Rezoning Transportation Analysis

Petition Number: 2019-152

From: Felix Obregon, PE
fobregon@charlottenc.gov
704-432-5729

RZ-1

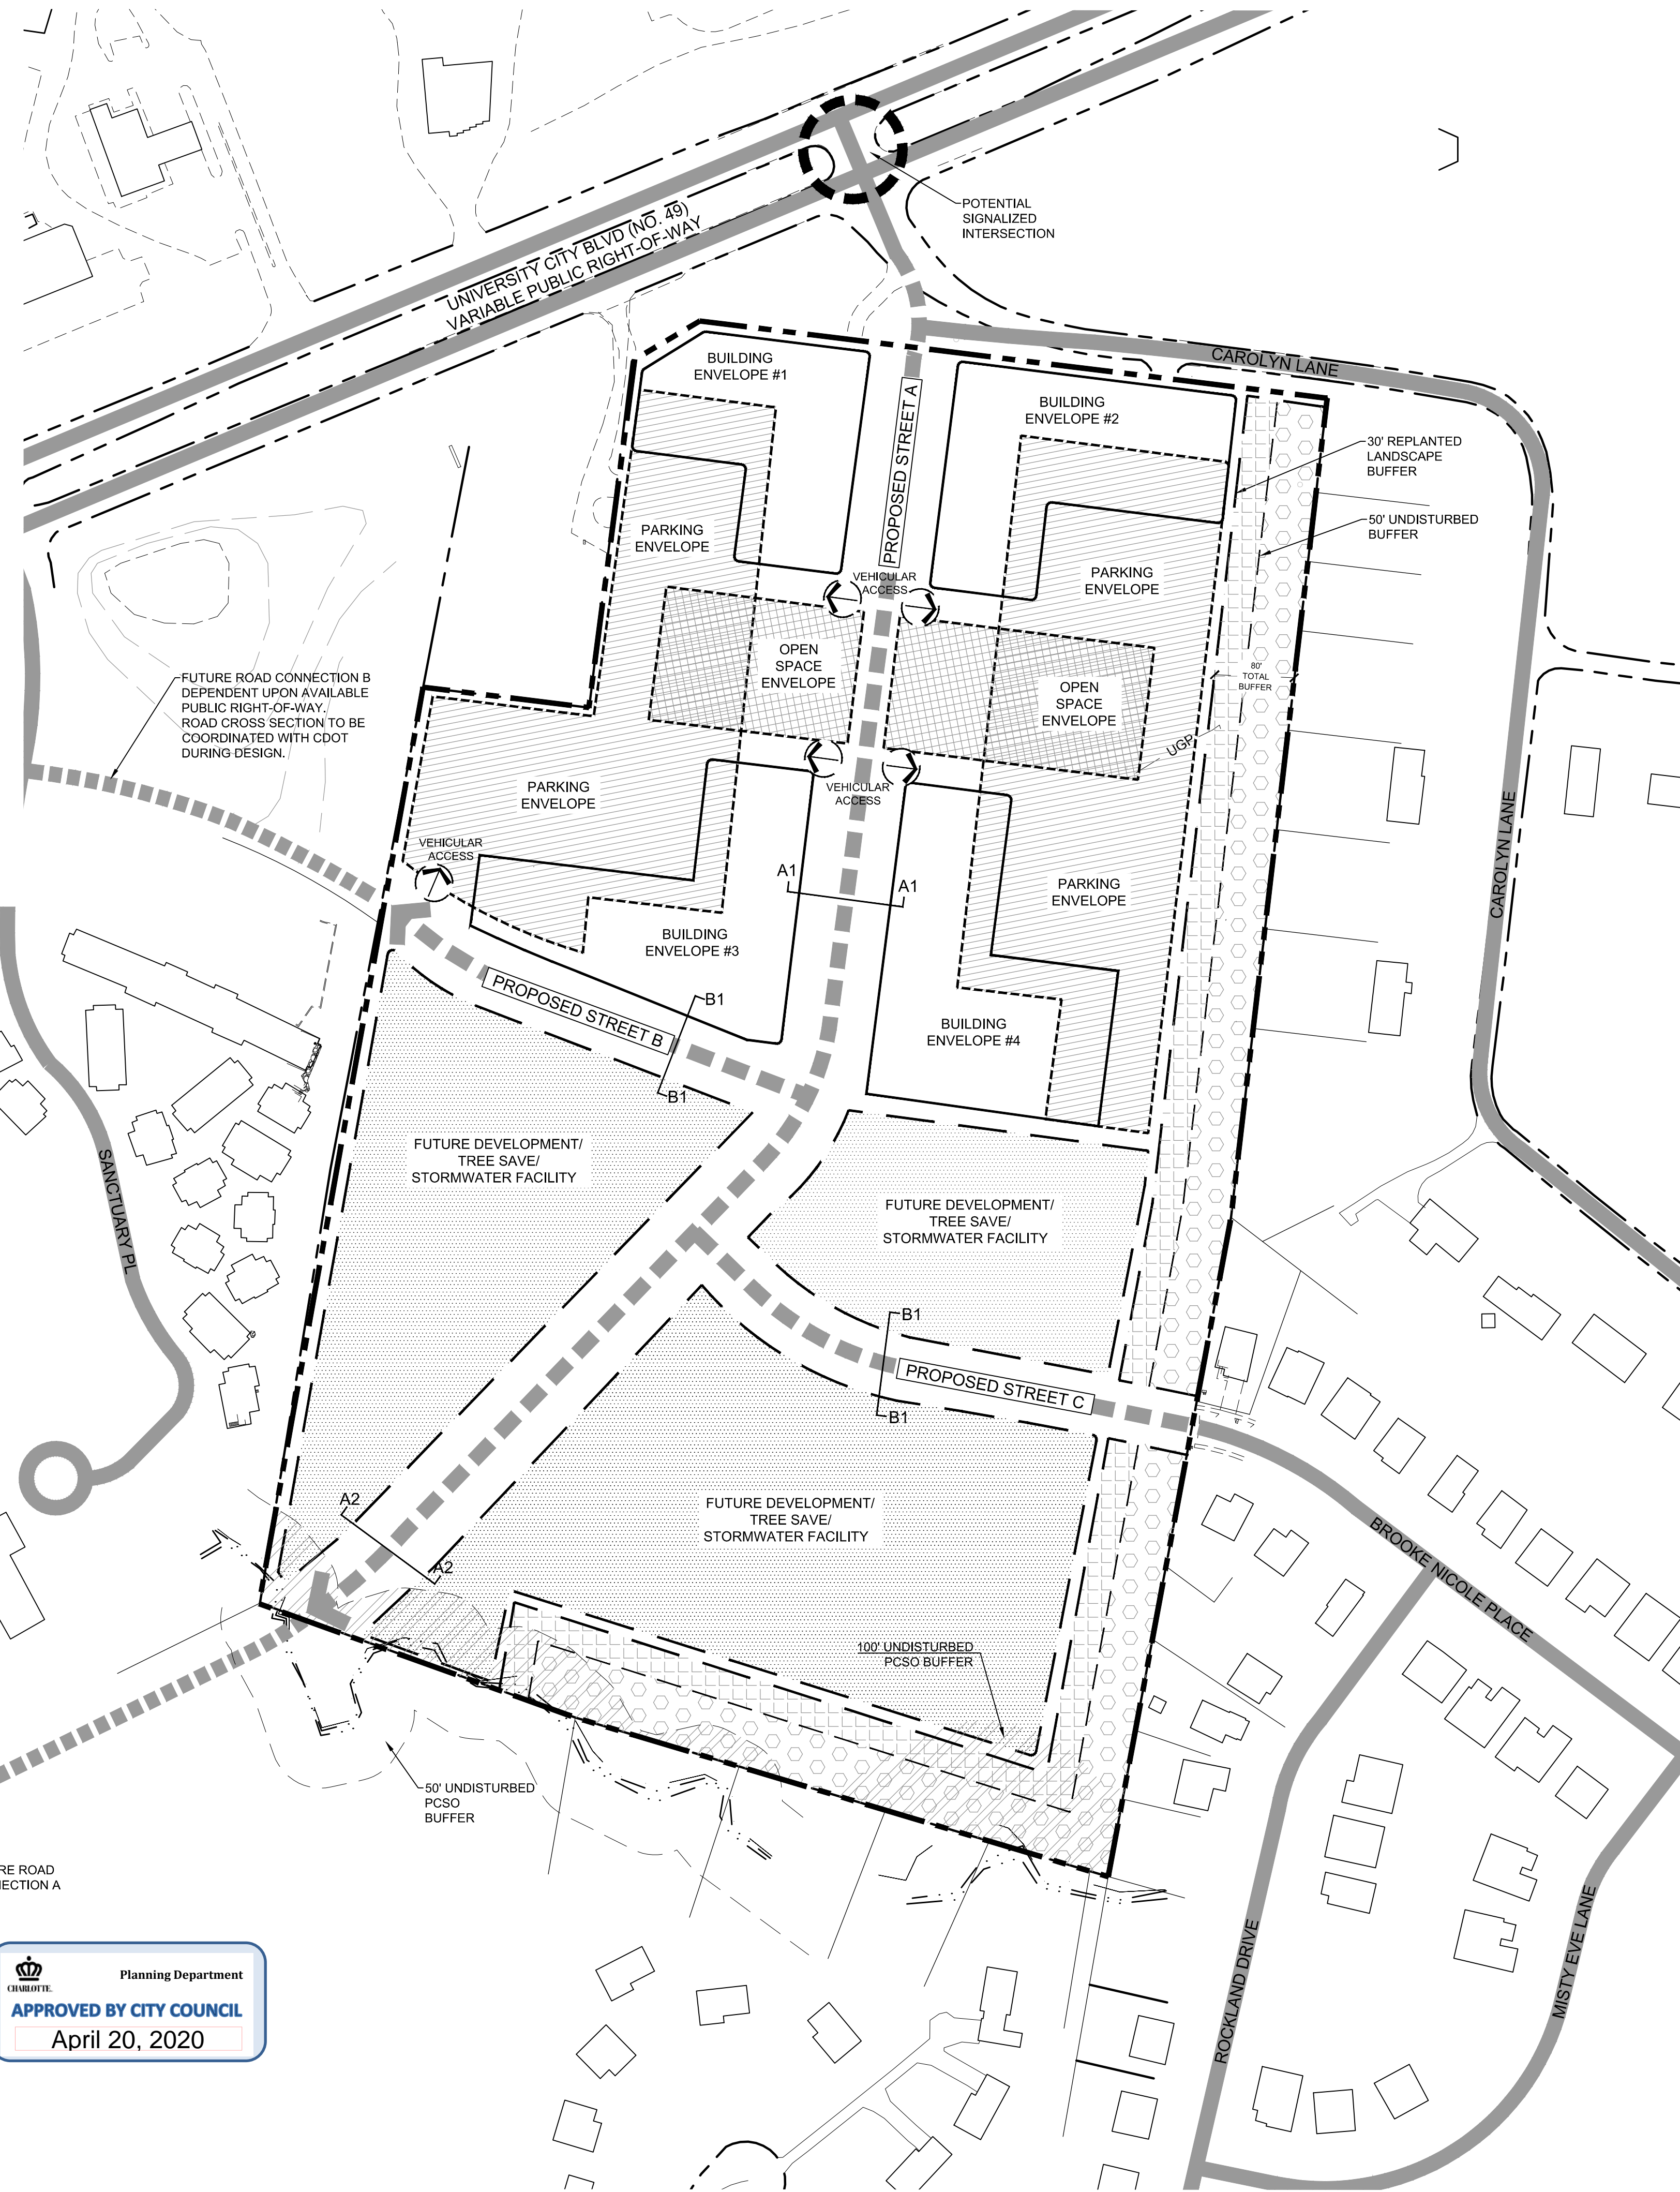
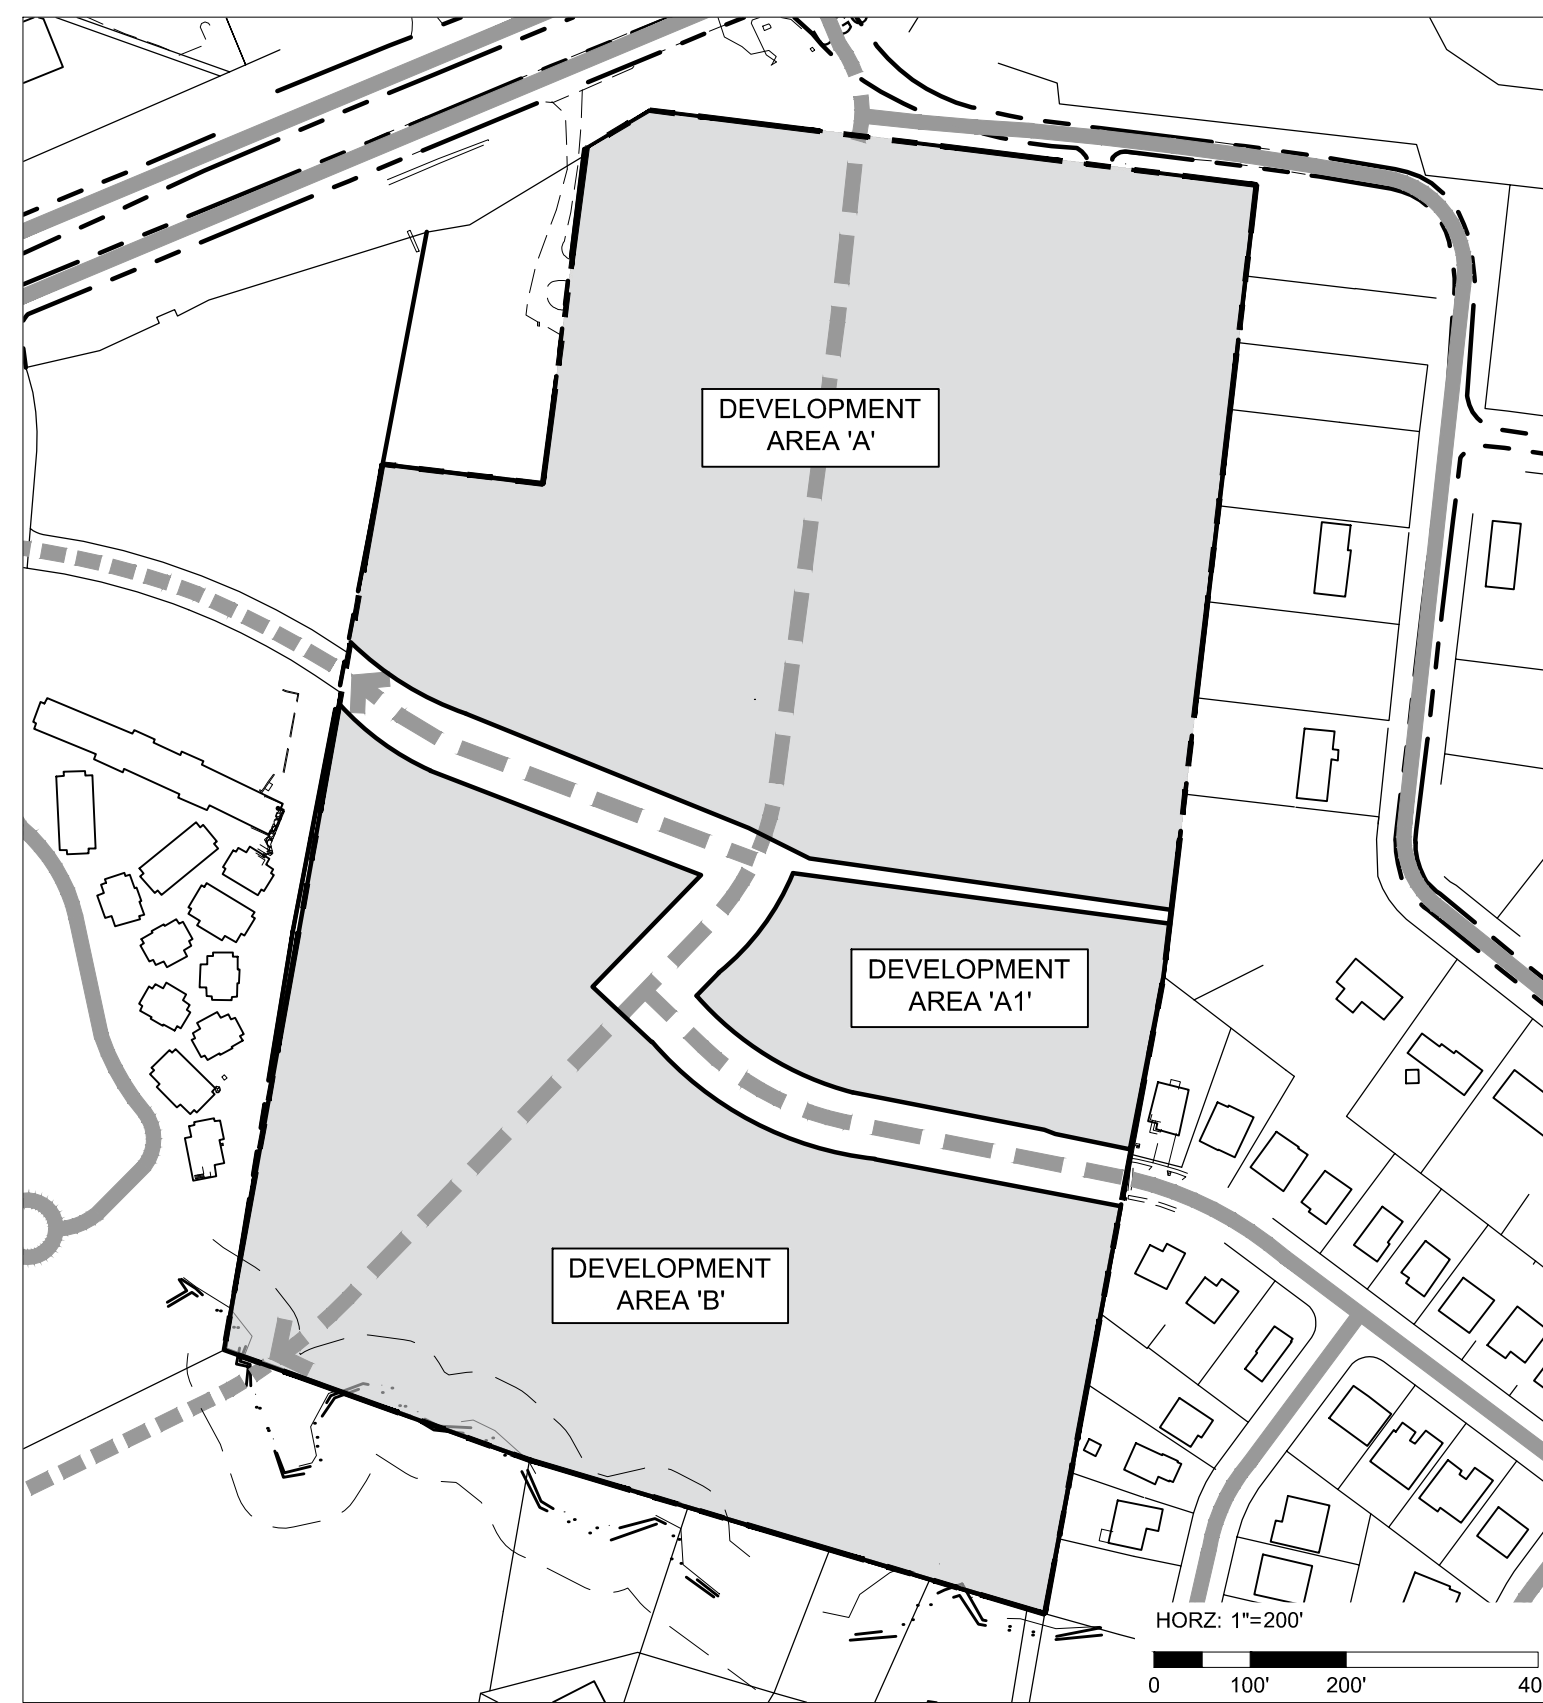
The site plan should show the curb and gutter labeled and dimensioned from the centerline for each road.

RZ-2

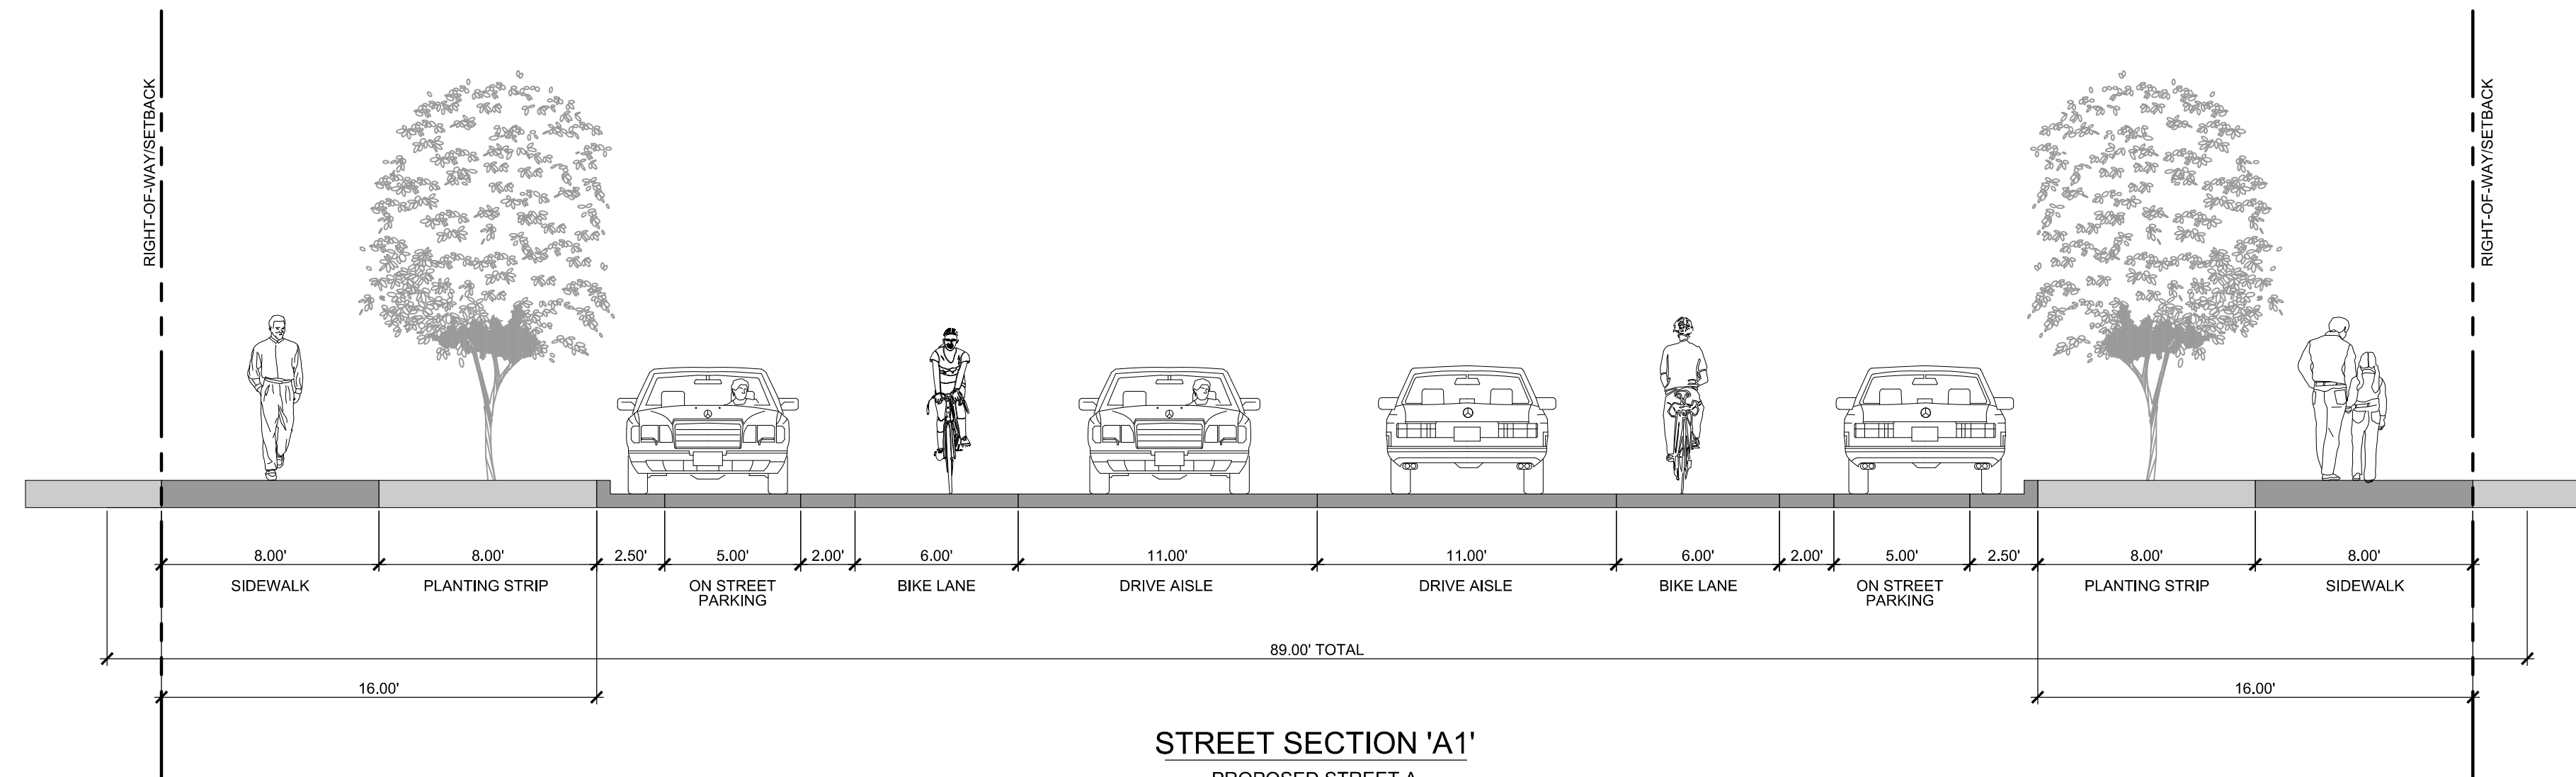
7. New Comment based on revise site plan (1/15/2020) The petitioner should revise the site plan to add a note 3.l.h specifying the speed humps will be installed by the petitioner, and not CDOT, once it meets the speed hump warrants.

- a. **Revised Comment based on site plan (02-24-20)** The petitioner should revise the conditional note 3.l.i to remove "expire after the last certificate of occupancy", and instead state it will expire after 5 years of receiving the last certificate of occupancy.

8. **New Comment based on revise site plan (02-24-2020)** The petitioner should revise the conditional note(s) 3.l.d under Transportation Improvements and Access to commit to fund the traffic signal at Rocky River Road and Dave McKinney Road without the use of any City funds. In the previous site plan, the developer committed to paying for the signal and now wants to use City funds to pay for it. The Dave McKinney connection will provide a much-needed benefit to the development by providing direct access to the J.W. Clay Light Rail station.

9. **New Comment based on revised site plan (02-24-2020)** The petitioner should revise conditional note(s) 3.l.e to state the developer commits to construct Twitter Lane, rather than stating it "may" because it may not happen. The connection to Twitter needs to happen as it will provide relief, and it was part of the Traffic Impact Study.

10. **New Comment based on revised site plan (02-24-2020)** The petitioner should revise conditional note(s) 3.l.g to state the developer will pay for this improvements to the City as part of the Dave McKinney Road Extension and Rocky River Road North East Corridor Infrastructure Program.
